WELWYN HATFIELD BOROUGH COUNCIL – DEVELOPMENT MANAGEMENT
DELEGATED REPORT

APPLICATION No:	S6/2013/1748/FP
APPLICATION Site:	1 The Cottages, Shepherds Way

DESCRIPTION OF PROPOSAL:

Date	Scale	Drawn	Drawing No.	Rev.
NOV'11	SHOWN	KEE	5896-02	A

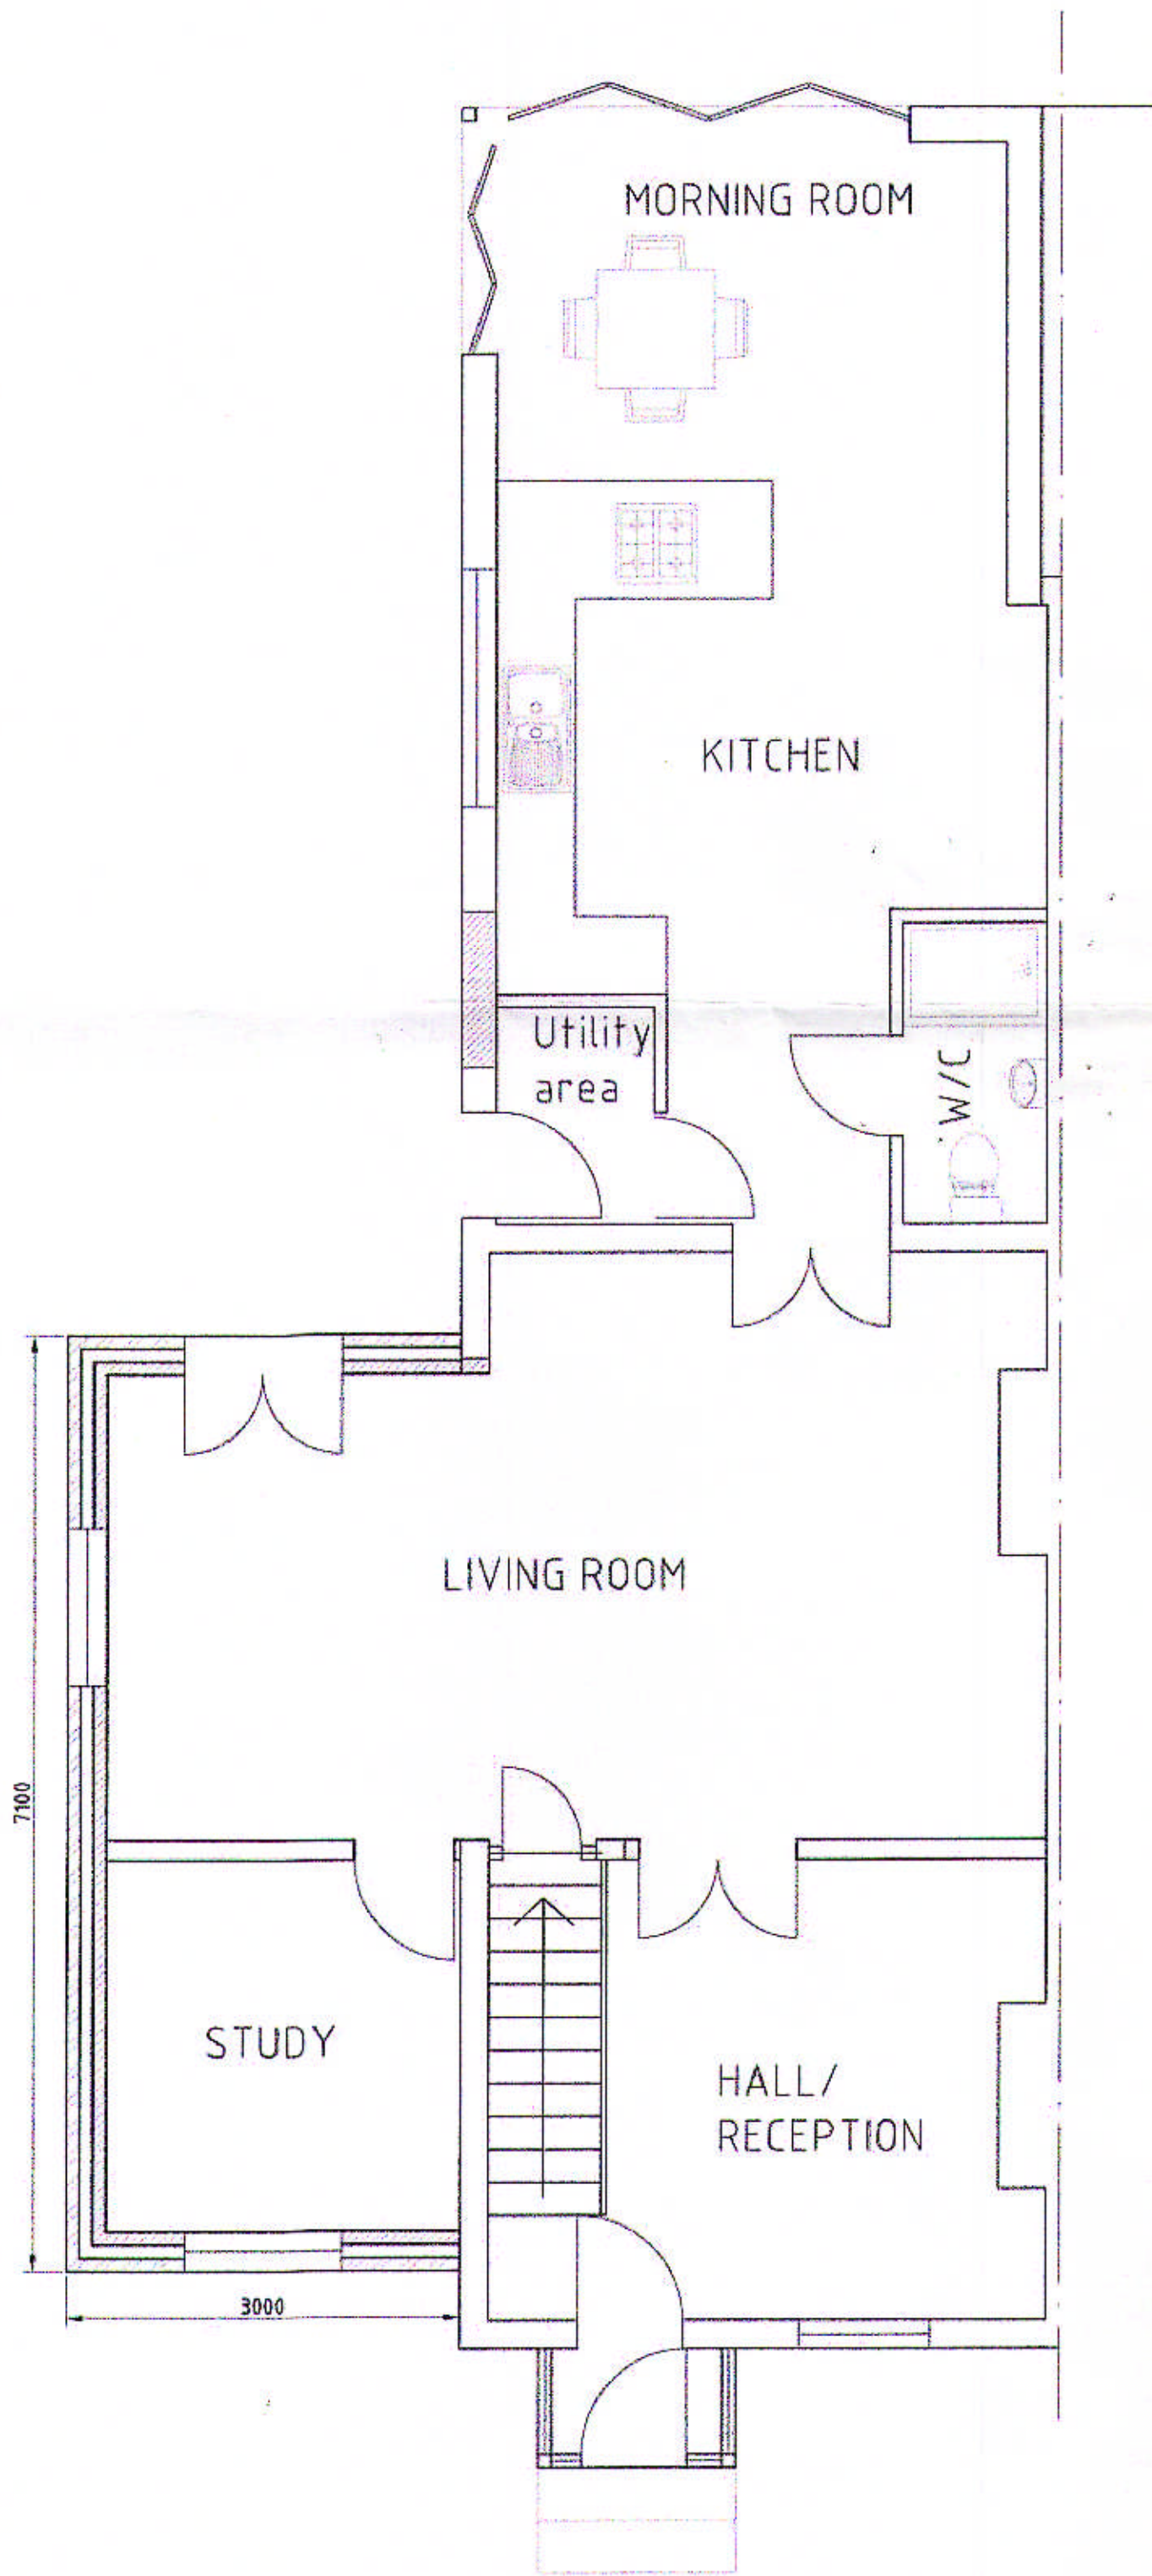
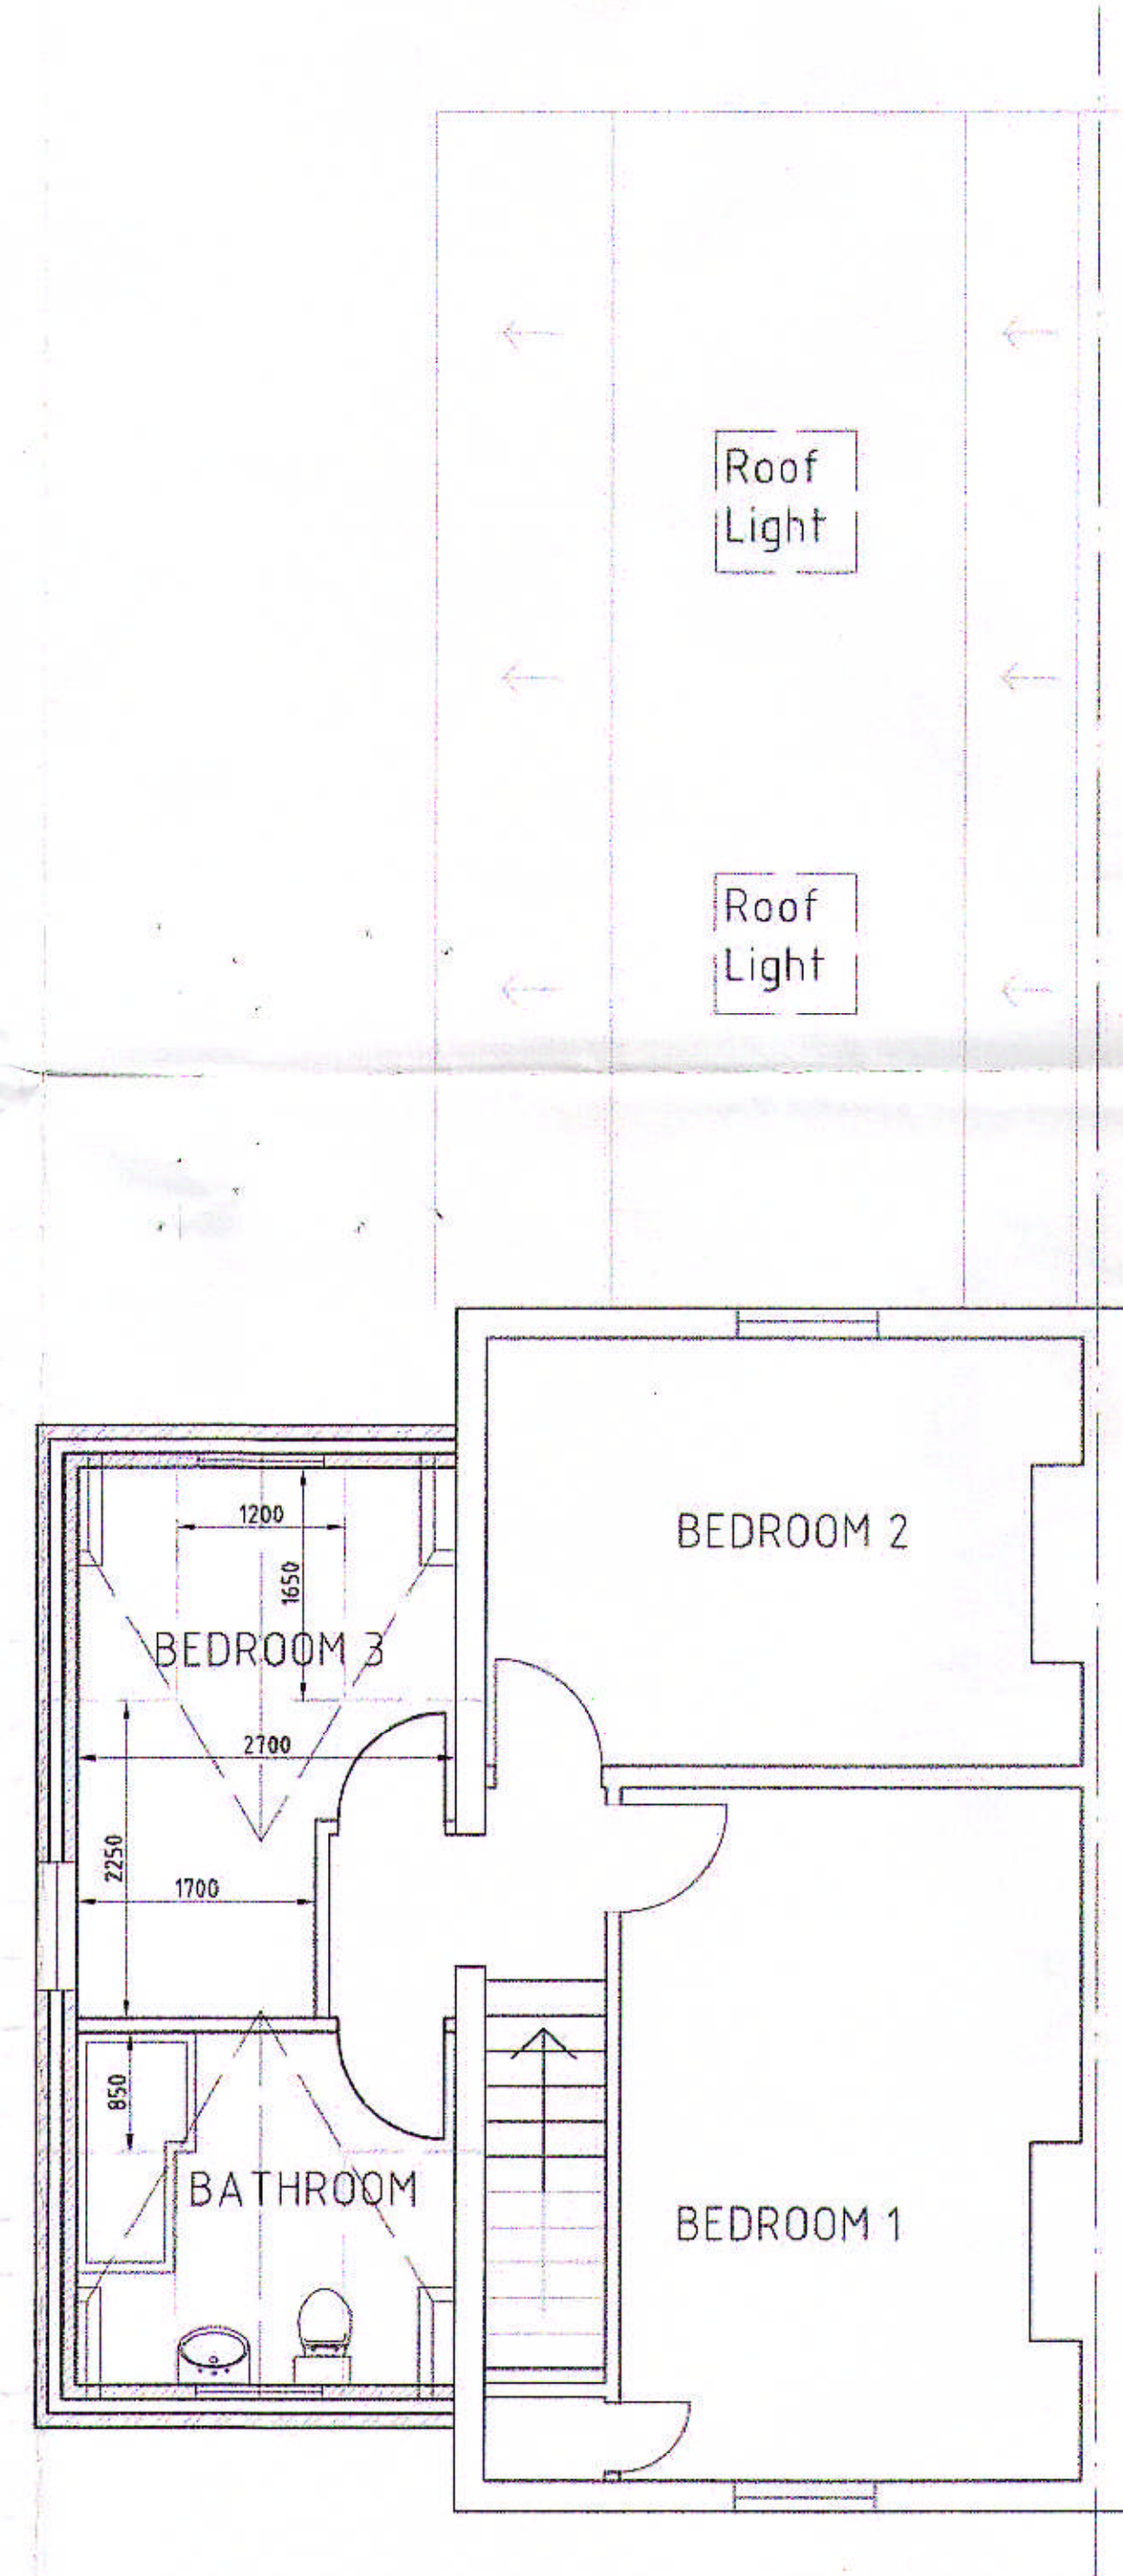
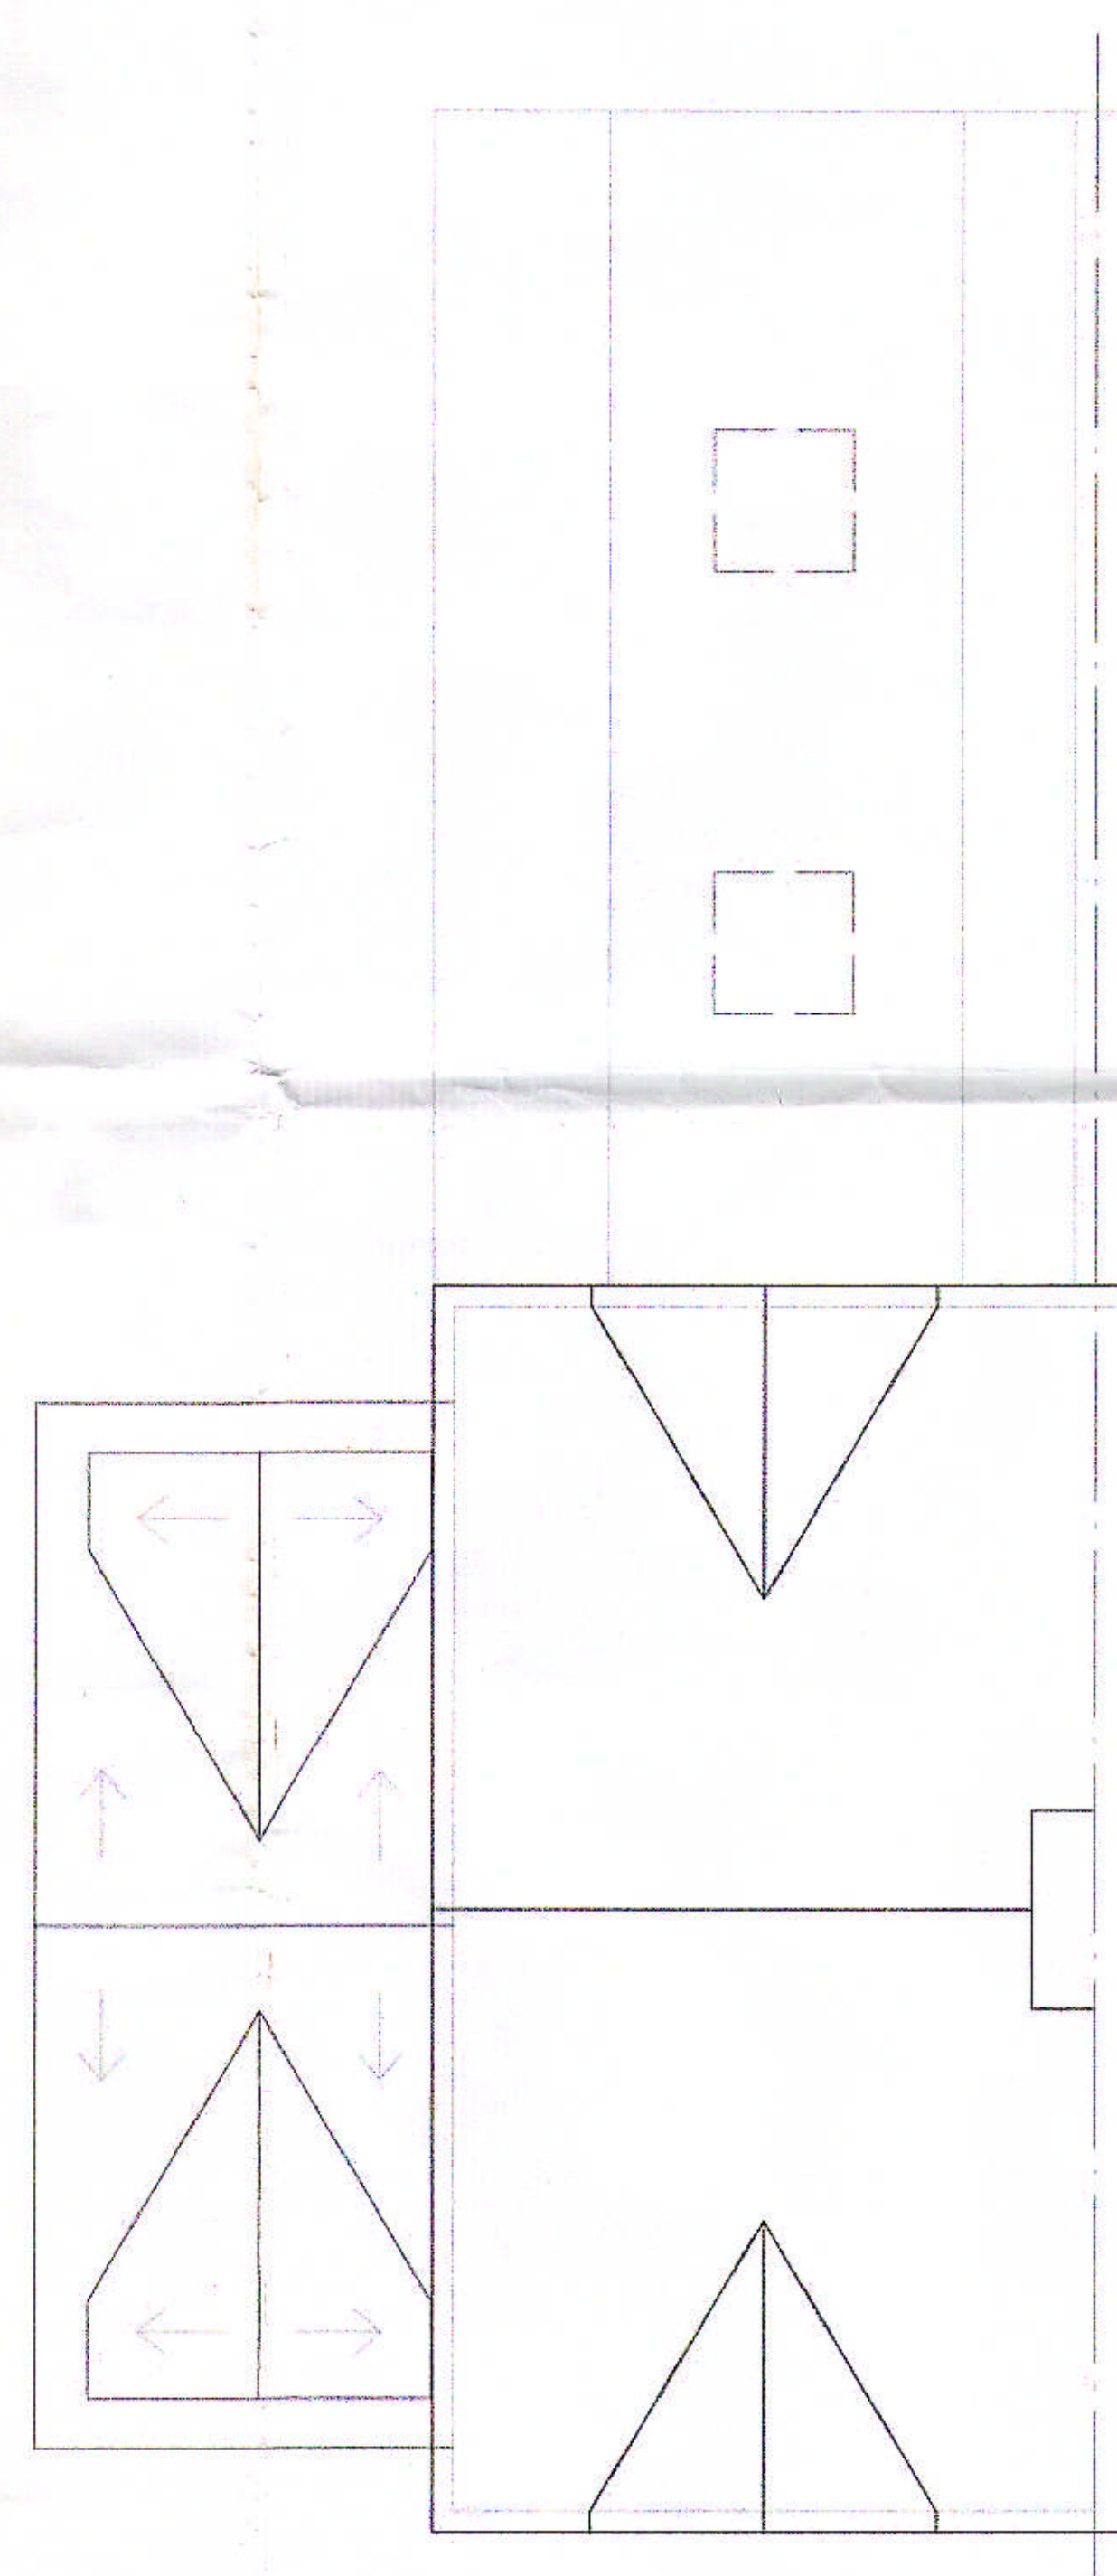
This application seeks full planning permission for the erection of two storey side extension, installation of velux windows to existing single storey rear extension. The two storey side extension would measure approximately 7.1m in depth and 3m in width. The extension would be set in approximately 600mm from the front elevation of the application dwelling and approximately 850mm from the main rear elevation. The roof would be gabled in design with a ridge height of approximately 6.8m which would be approximately 900mm below the main ridge of the dwelling. The roof would feature a dormer window to the front and rear. The extensions would be finished in materials to match the existing dwelling.

The proposed extensions would result in a total floorspace of approximately 162sqm which is equivalent to a 76% increase over-and-above the original dwelling. The footprint would increase to approximately 101sqm or a 90% increase over-and-above the original dwelling. The proposal is therefore regarded as inappropriate development in the Green Belt which is by definition, substantially harmful to the Green Belt contrary to the National Planning Policy Framework, March 2012 and Policy RA3(i).

Due to the orientation and the close proximity of the application dwelling to the highway at the side of the site, the two storey extension would be highly visible from viewpoints travelling along Shepherds Way. Despite a lower ridge and set backs at the front and rear the extension would represent significant additional bulk. The increased scale of the dwelling and the resultant intrusion in to the Green Belt would fail to maintain the character of the area contrary to criterion (ii) of Policy RA3 and the objectives of Policies D1 and D2. As a result, the harm in this respect is also afforded a significant degree of weight.

1. C.2.1 – Time Limit
2. C.13.1 – The development/works shall not be started and completed other than in accordance with the approved plans and details 5896-02 Rev A received and dated 2 September 2013
